COLORADO
Department of Transportation

January 21, 2021

RE: Crossroads at Meadowbrook Mixed Use Preliminary Plan - SH24G/SH94A EPC
SP2011

File: C:\180031A-Crossroads Mixed Use\Colorado Springs Equities LLC\dwg\PRELIM GRADING\GR02.dwg Plotstamp: 11/23/2020 12:05 PM

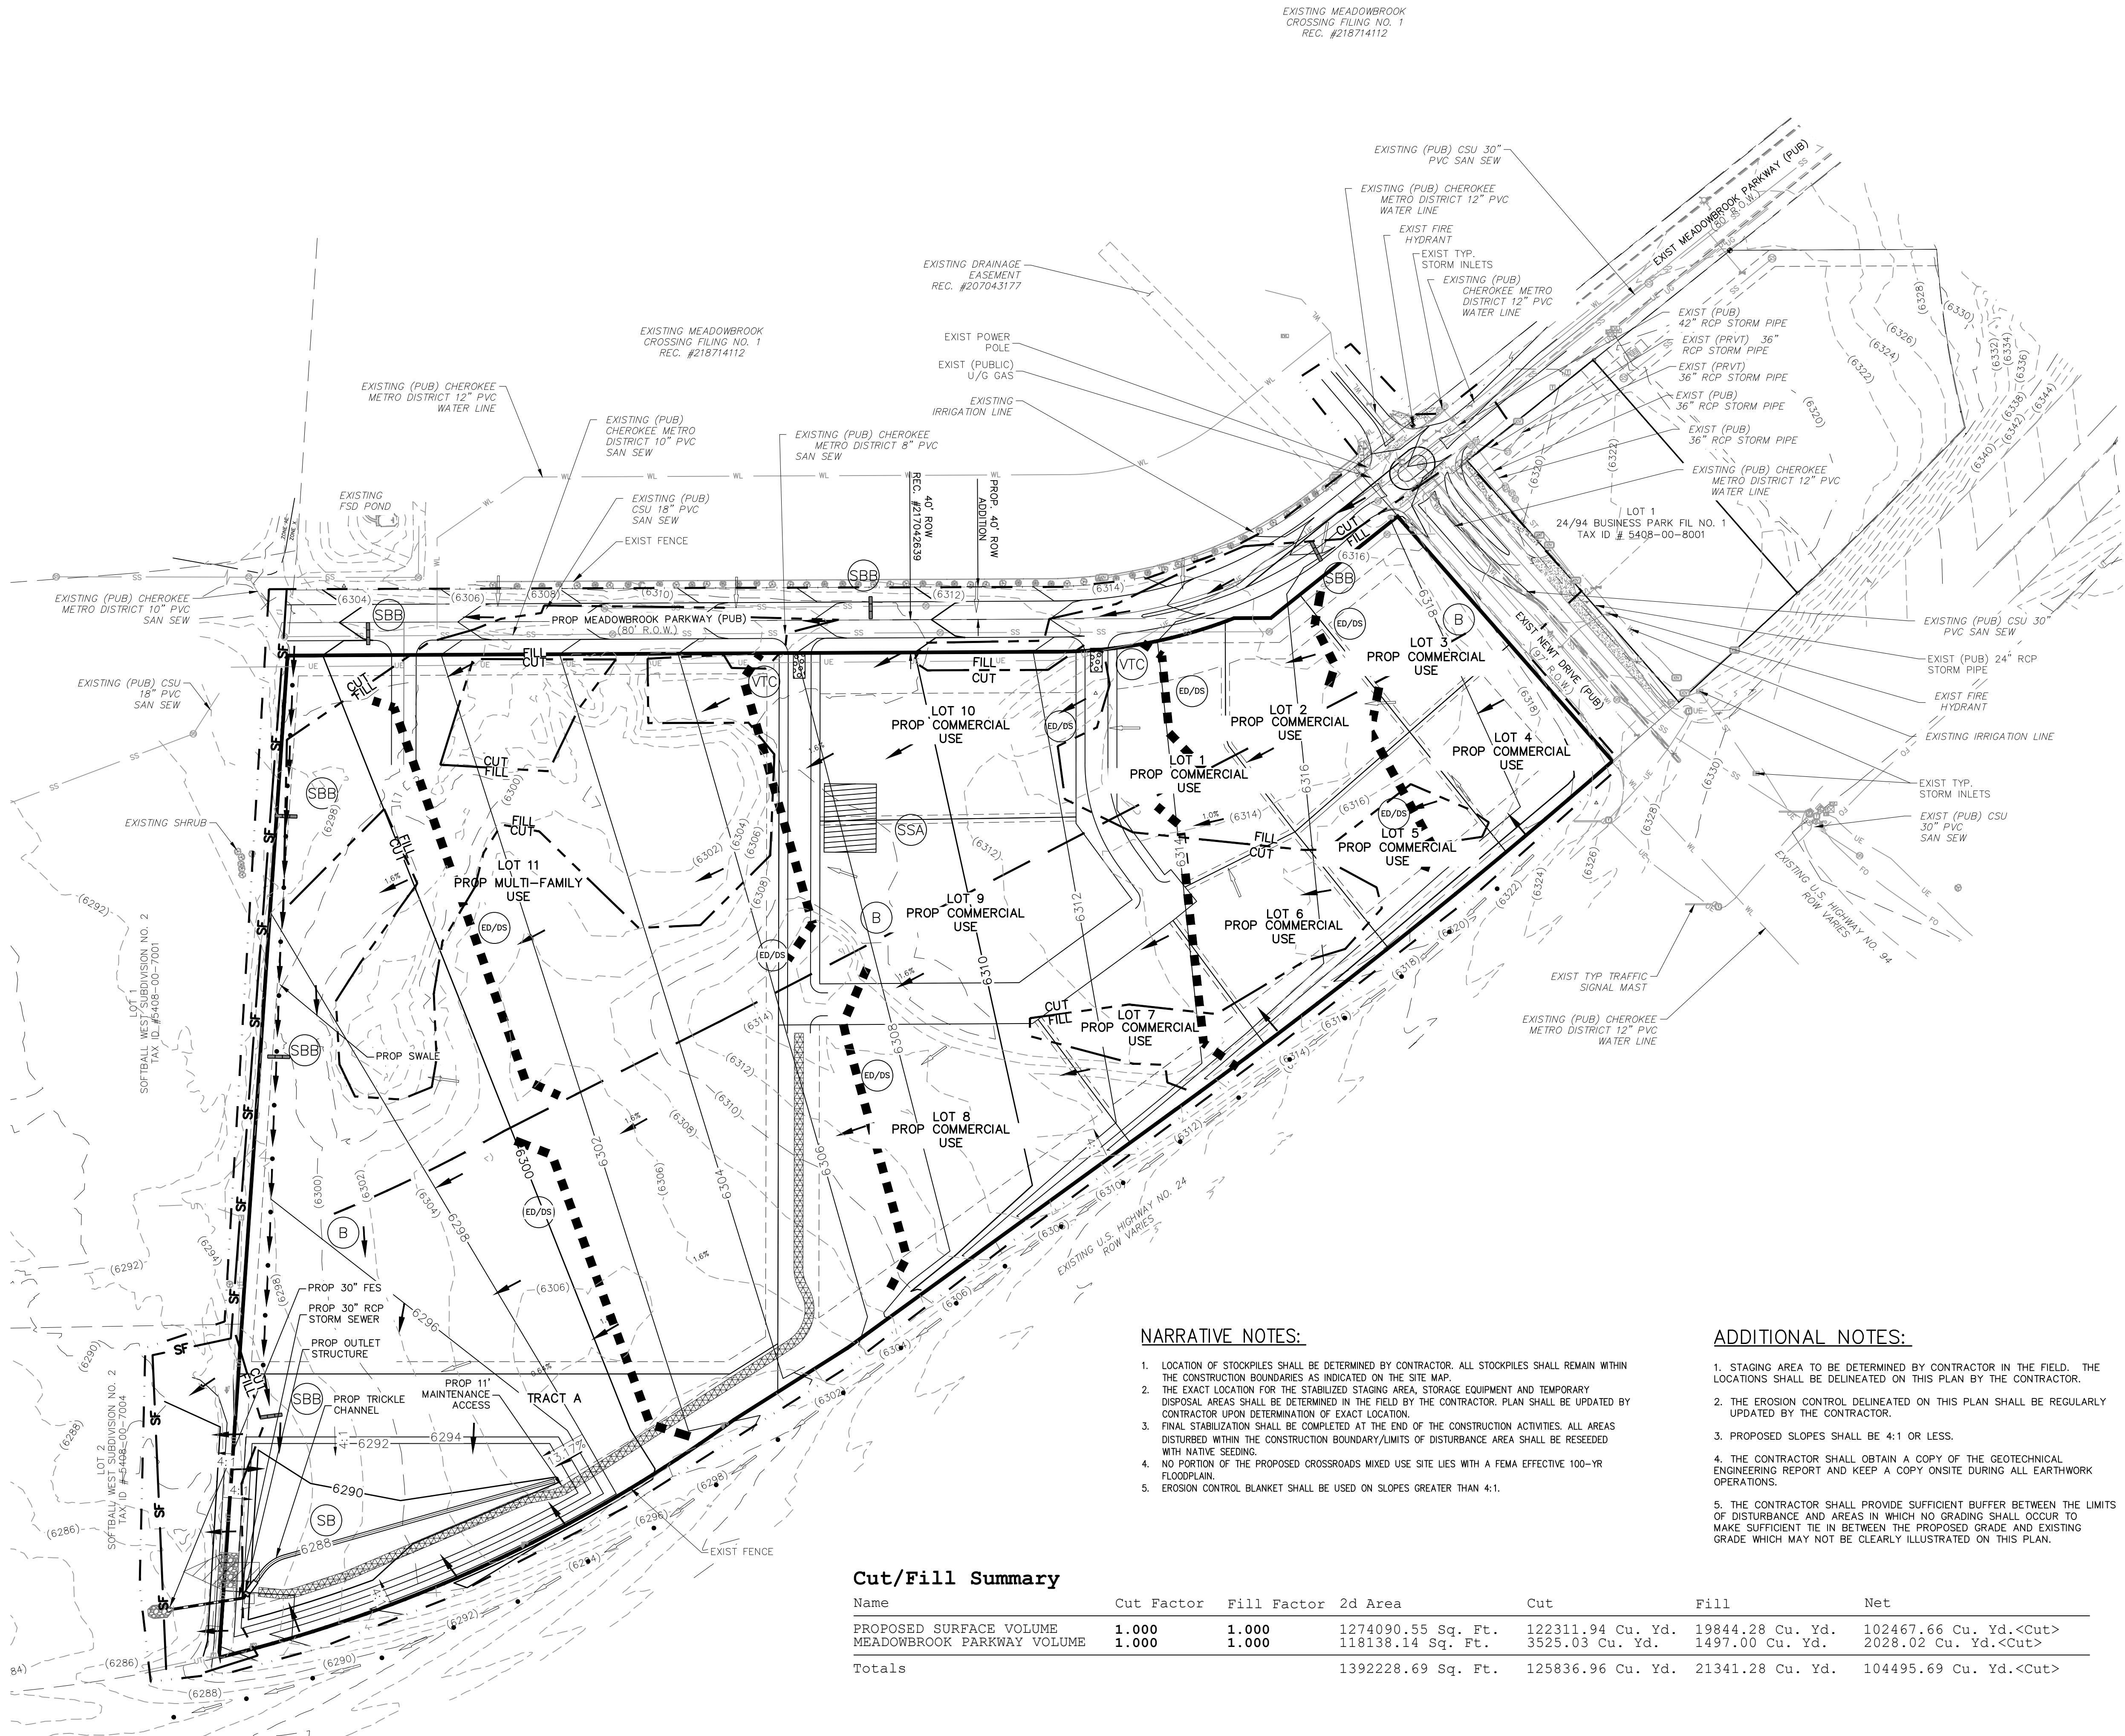
- This project doesn't seem to directly affect CDOT facilities with the current design. My only concern is the outfall of the detention pond. The report states that the outfall discharges into an existing swale. This swale is not well defined. The existing condition is natural sheet flow across the basin and will be concentrated flow in the proposed condition at the outfall. In the final design I would suggest the engineer ensure the swale can handle the concentrated flows without erosion of the channel bottom.

- The highway drainage system is for the protection of the state highway right-of-way, structures, and appurtenances. It is not designed nor intended to serve the drainage requirement of abutting or other properties beyond undeveloped historical flow. Drainage to the state highway right-of-way shall not exceed the undeveloped historical rate of flow.

- CDOT would like to emphasize this development devise and implement a permanent plan for periodic removal and disposal of sediment from detention facilities and for maintenance of development detention facilities not within CDOT Rights of Way.
